Portland, Maine

May 29, 2015

CBL: 017 E014001
Located at: 40 WATERVILLE ST

Inspection Violations

SHEET TITLE FIRST FLOOR PLAN

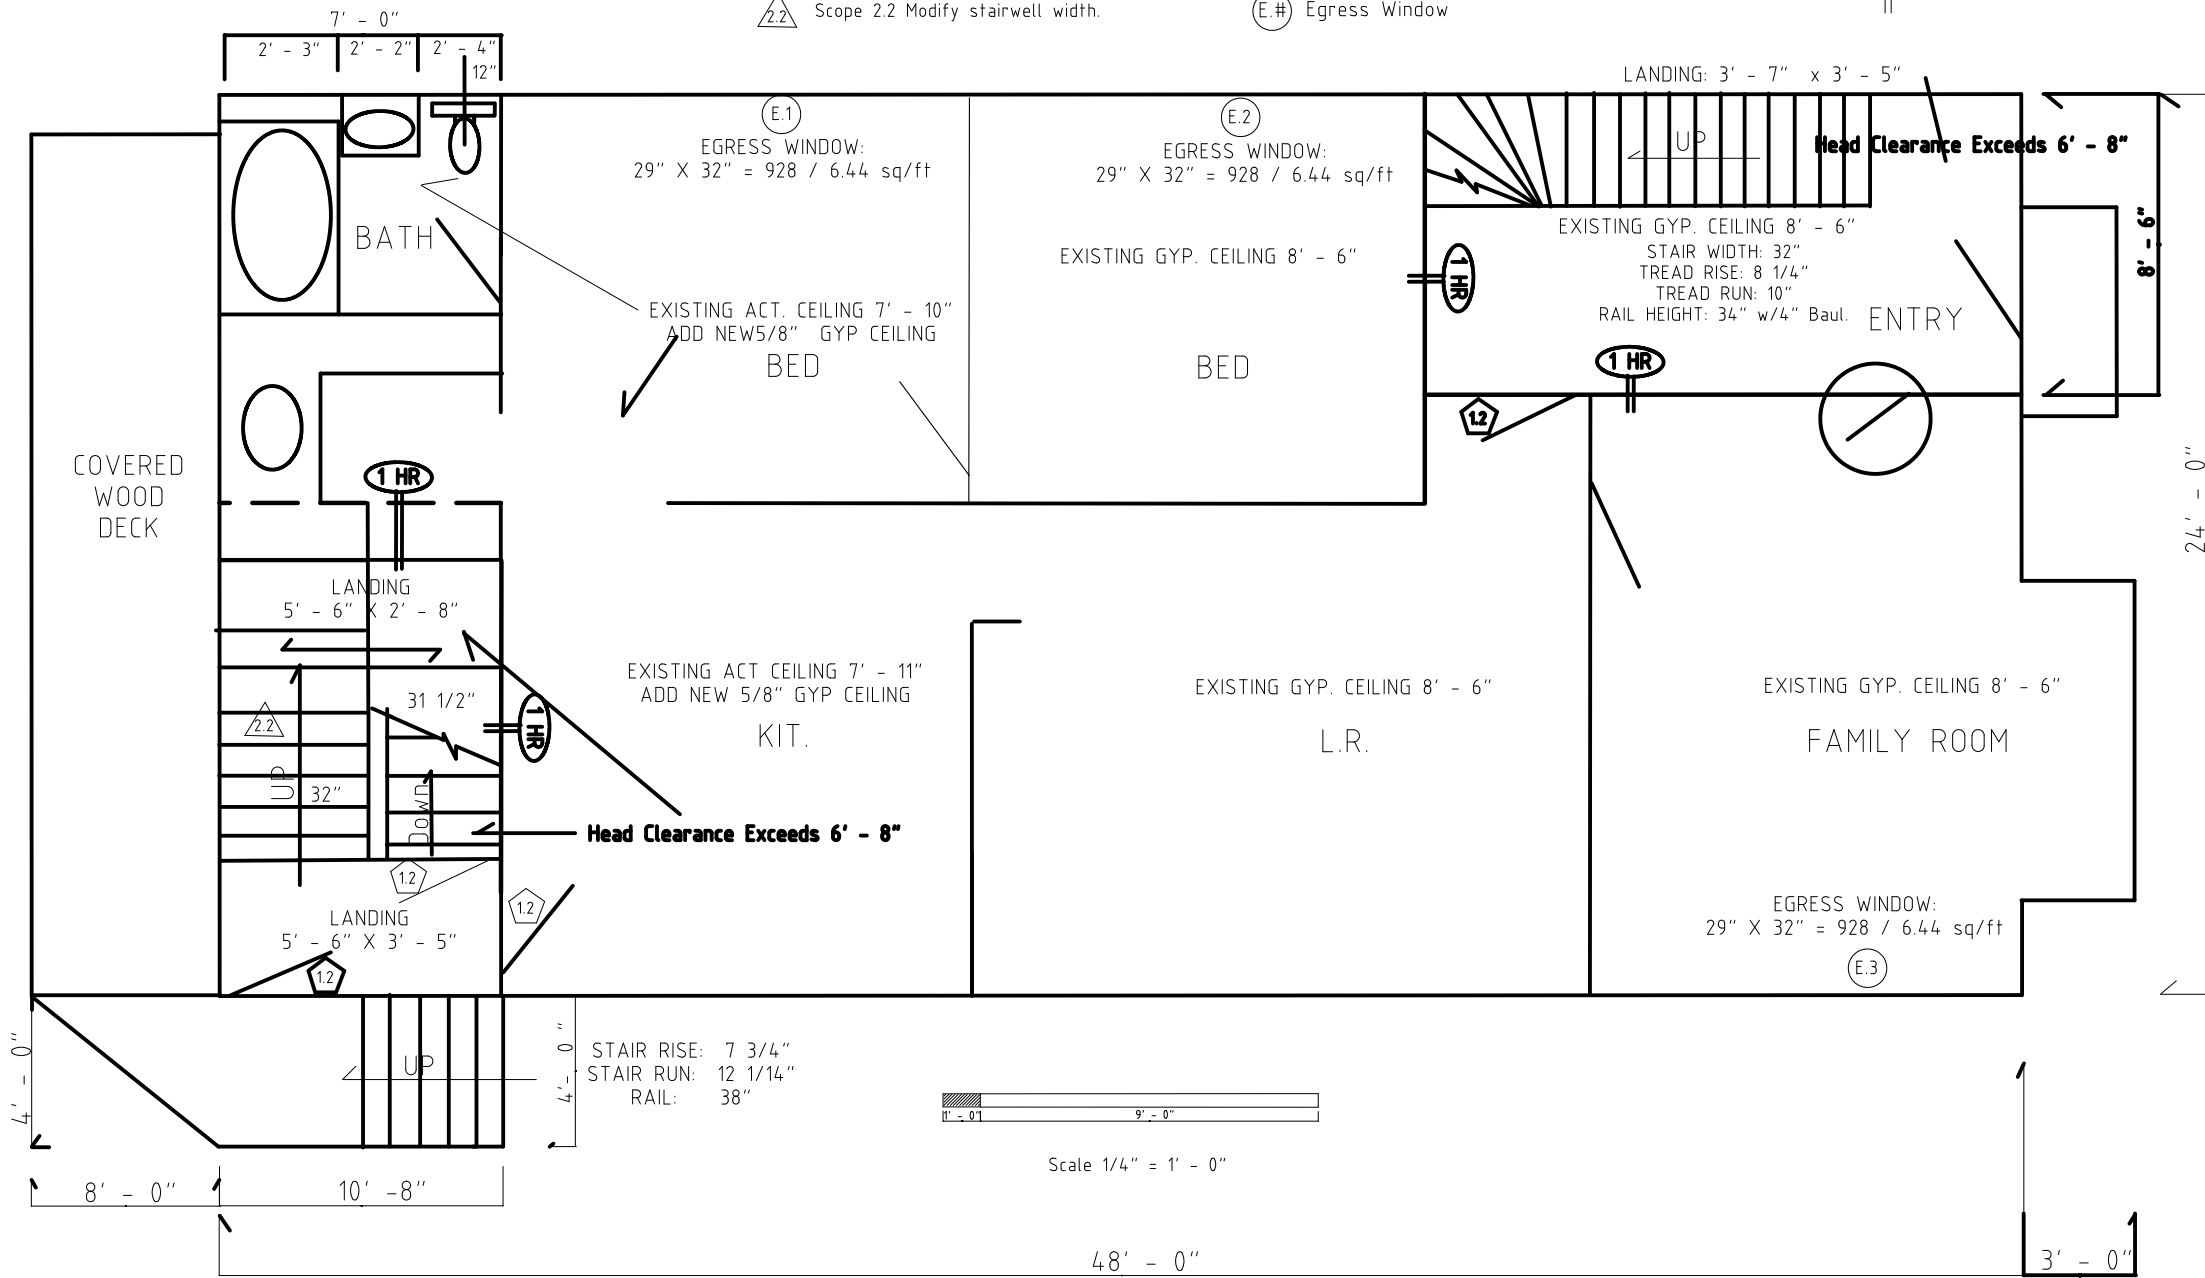
Violation: NFPA 101- 31.3.3.2 INTERIOR FINISH; INTERIOR WALL AND CEILING FINISH MATERIALS COMPLYING WITH 10.2 SHALL BE PERMITTED AS FOLLOWS:
(1) EXIT ENCLOSURES- CLASS A OR B
(2) LOBBIES AND CORRIDORS- CLASS A OR B
(3) OTHER SPACES- CLASS A, B, OR C.

Notes: HALLWAY FINISH SHOULD BE DRYWALL

SHEET TITLE  
**BASEMENT  
ELECTRICAL  
PLAN  
A.1.4**

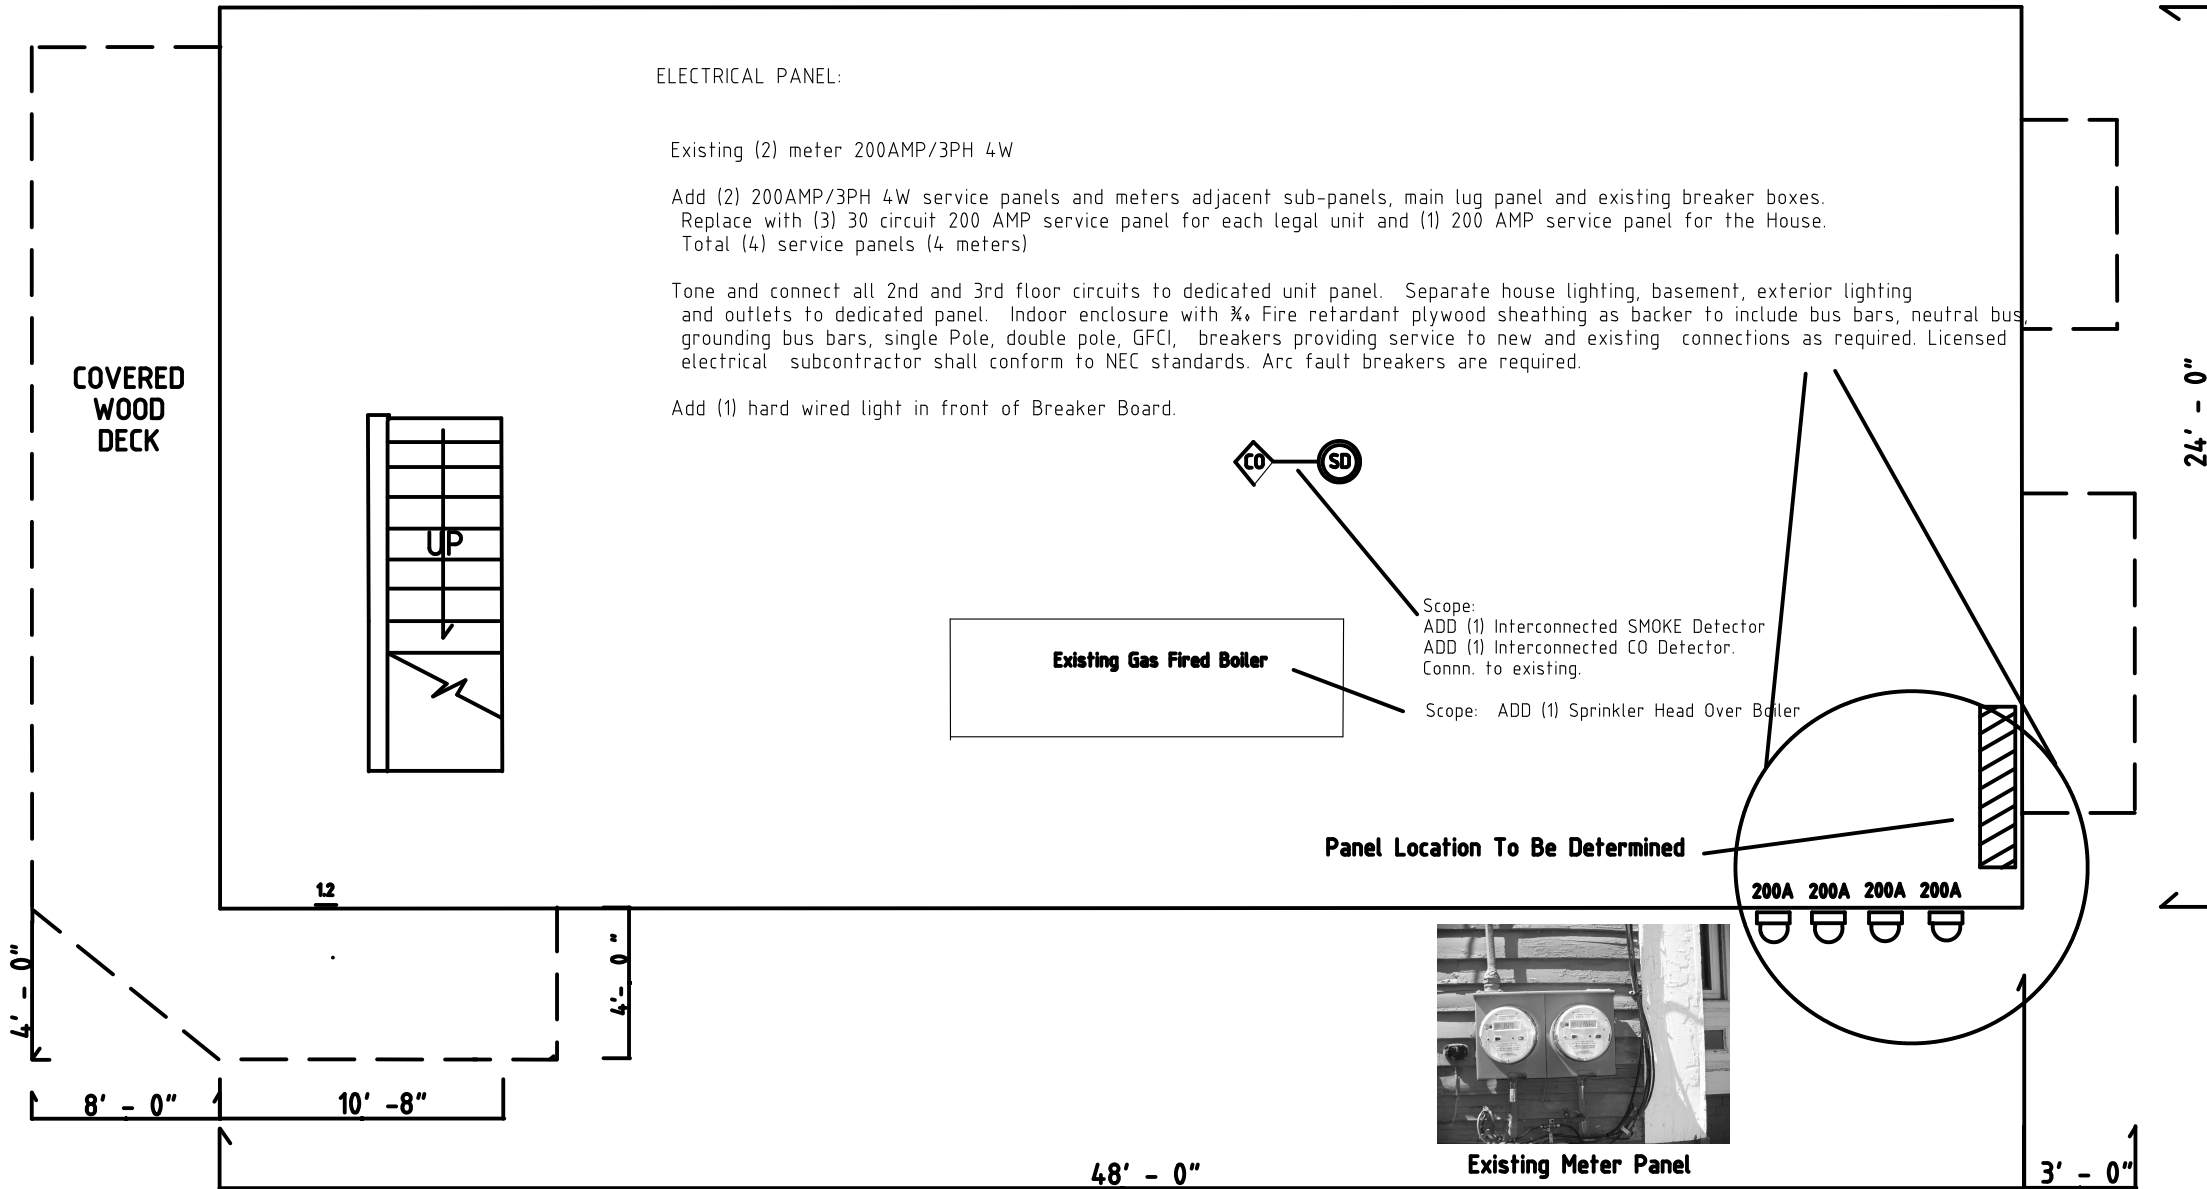
3) 6-113.(e)	Interior	3	3	Electrical Panel	
Violation:	MAINTENANCE OF LIGHTING FIXTURES; Maintenance of lighting fixtures. All fixtures required by this article and all fixtures installed in addition thereto shall be maintained in good and safe working conditions and shall be installed in accordance with the electrical code of the city.				
Notes:	A separate service is required for the proposed dwelling unit.				
Comments:	Third floor is an illegal unit. Rear Decks appear to have been built without a permit, need structural engineer approval. It is unknown what the ledger to band joist is, but it is specifically not attached per code specs, ie; staggered 1/2 inch lag screws or listed product. There is also no lateral load connection in the prescribed two location minimum. Basement floor joist are supported at foundation wall with pressure treated lumber and adjustable columns, structural engineer will need to inspect and approve repairs. Several holes and penetrations need sealing above suspended ceiling for continuity (1st floor). Life safety needs complete updating from fire doors to updated smoke detectors as well as carbon monoxide detectors. Sprinkler needed in basement over the fuel fired furnace. To legalize the third unit the apartment will need it's own meter and a house meter added as well for all common area power.

Notes: SMOKE AND CO DETECTION IS REQUIRED IN BASEMENT AND HALLWAYS.
SMOKES AND CO DETECTORS THAT ARE >10 YEARS OLD SHOULD BE REPLACED.

Violation: NFPA 101- 31.3.2.1.1 BOILER PROTECTION REQUIRED; THE AREAS DESCRIBED IN TABLE 31.3.2.1.1 SHALL BE PROTECTED AS INDICATED:
BOILER AND FUEL-FIRED HEATER ROOMS SERVING MORE THAN A SINGLE DWELLING UNIT (MINIMUM SEPARATION/PROTECTION IS 1 HOUR OR SPRINKLERS)

Notes: SPRINKLER HEAD REQUIRED

SHEET TITLE DECK DETAIL

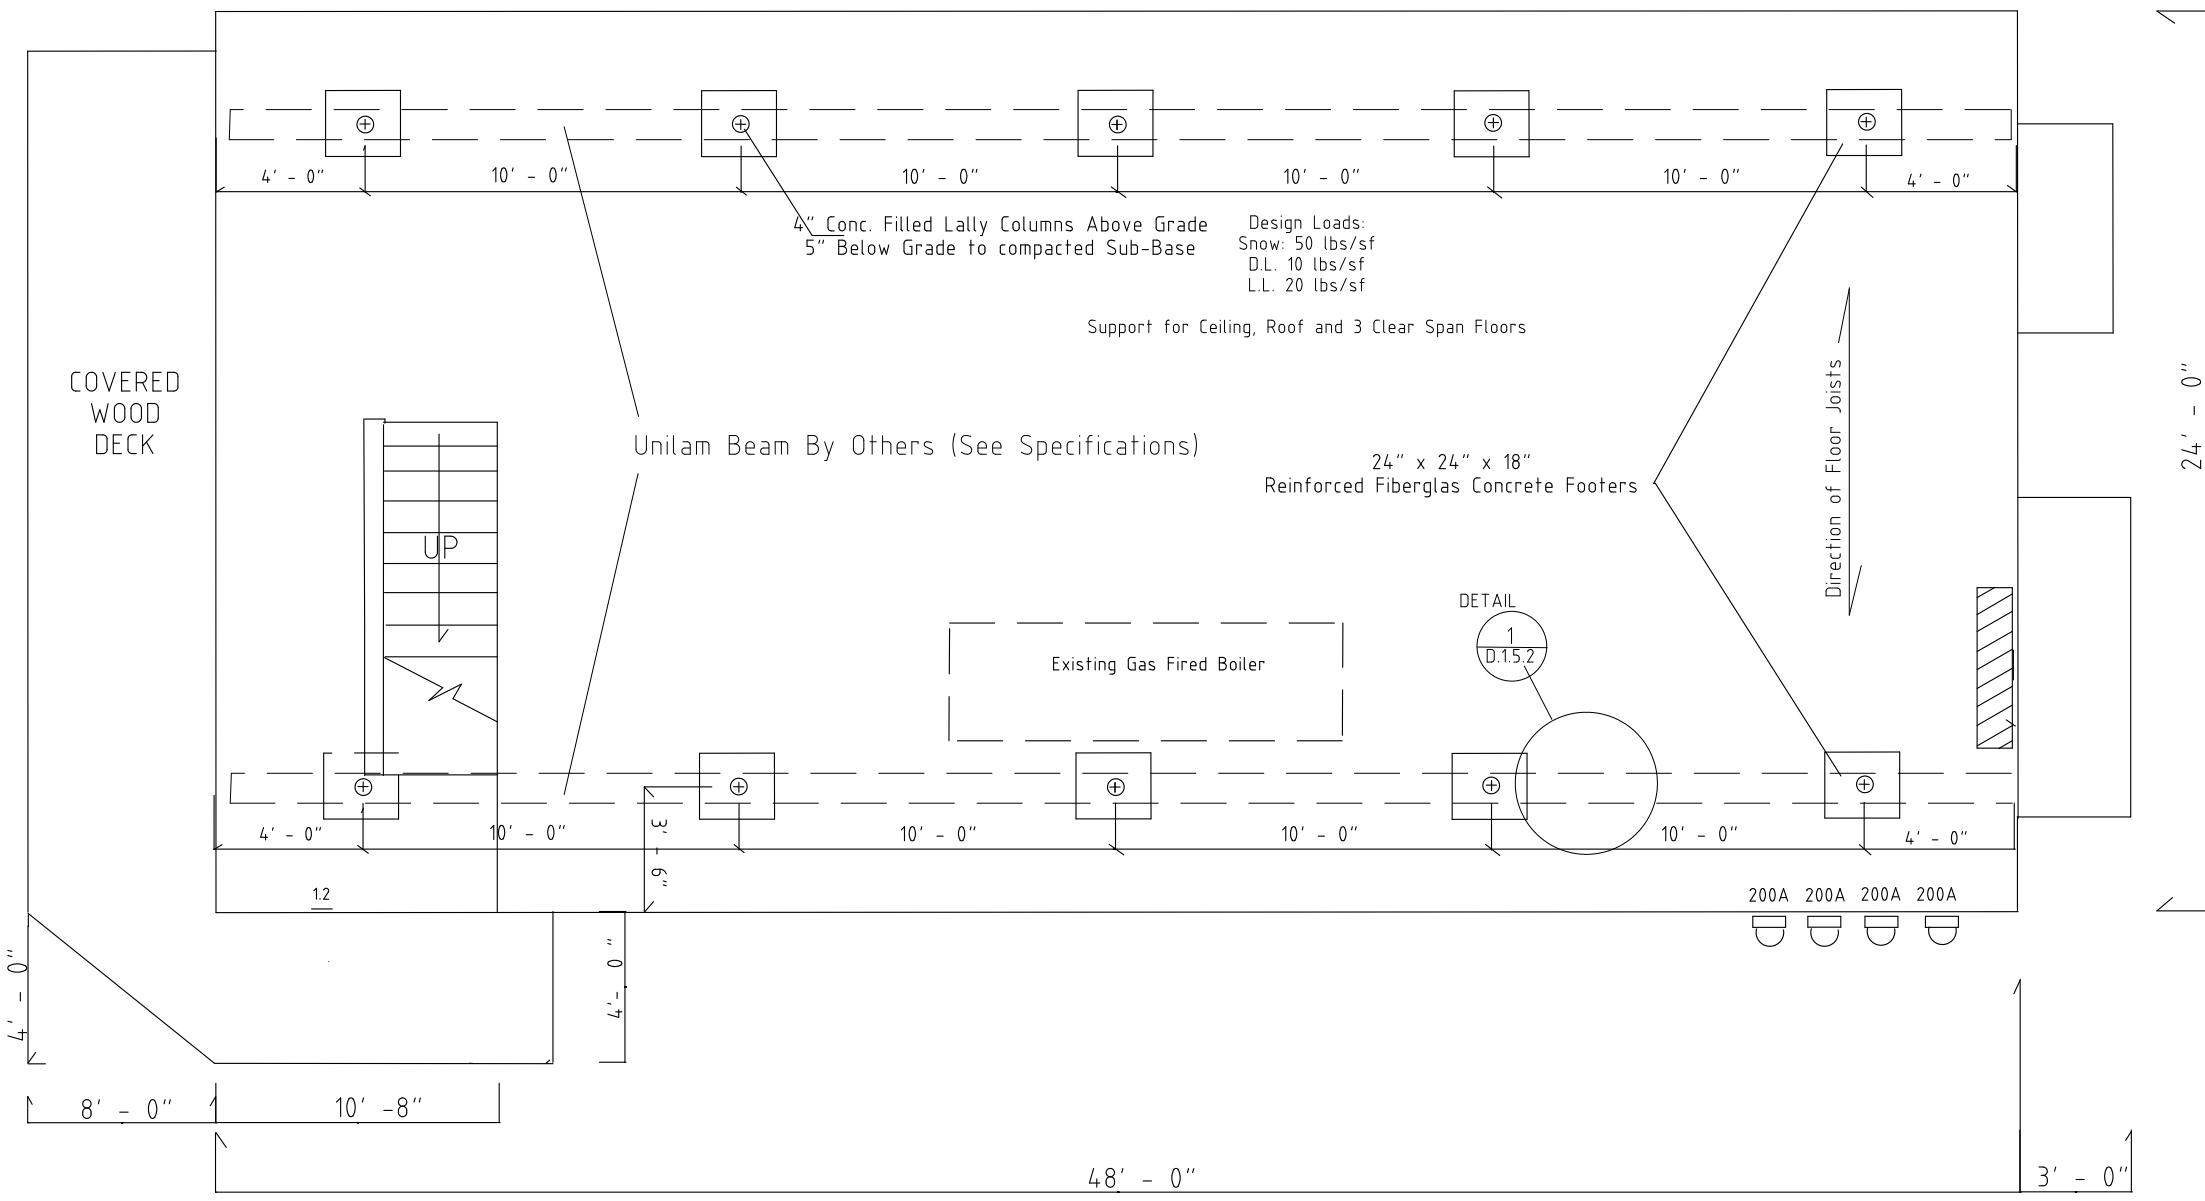
Code	Int/Ext	Floor	Unit No.	Area	Compliance Date
1) 105.1	Exterior			Deck	
Violation:	BUILDING W/O PERMIT; Any owner or authorized agent who intends to construct, enlarge, alter, repair move, demolish, or change the occupancy of a building or structure, or to erect, install, enlarge, alter, repair, remove, convert or replace any electrical, gas, mechanical or plumbing system, the installation of which is regulated by this code, or to cause any such work to be done, shall first make application to the building official and obtain the required permit.				
Notes:	See Letter Dated 04/21/2015 from the Zoning Administrator.

Comments: Third floor is an illegal unit. Rear Decks appear to have been built without a permit, need structural engineer approval. It is unknown what the ledger to band joist is, but it is specifically not attached per code specs, ie; staggered 1/2 inch lag screws or listed product. There is also no lateral load connection in the prescribed two location minimum. Basement floor joist are supported at foundation wall with pressure treated lumber and adjustable columns, structural engineer will need to inspect and approve repairs. Several holes and penetrations need sealing above suspended ceiling for continuity (1st floor). Life safety needs complete updating from fire doors to updated smoke detectors as well as carbon monoxide detectors. Sprinkler needed in basement over the fuel fired furnace. To legalize the third unit the apartment will need it's own meter and a house meter added as well for all common area power.
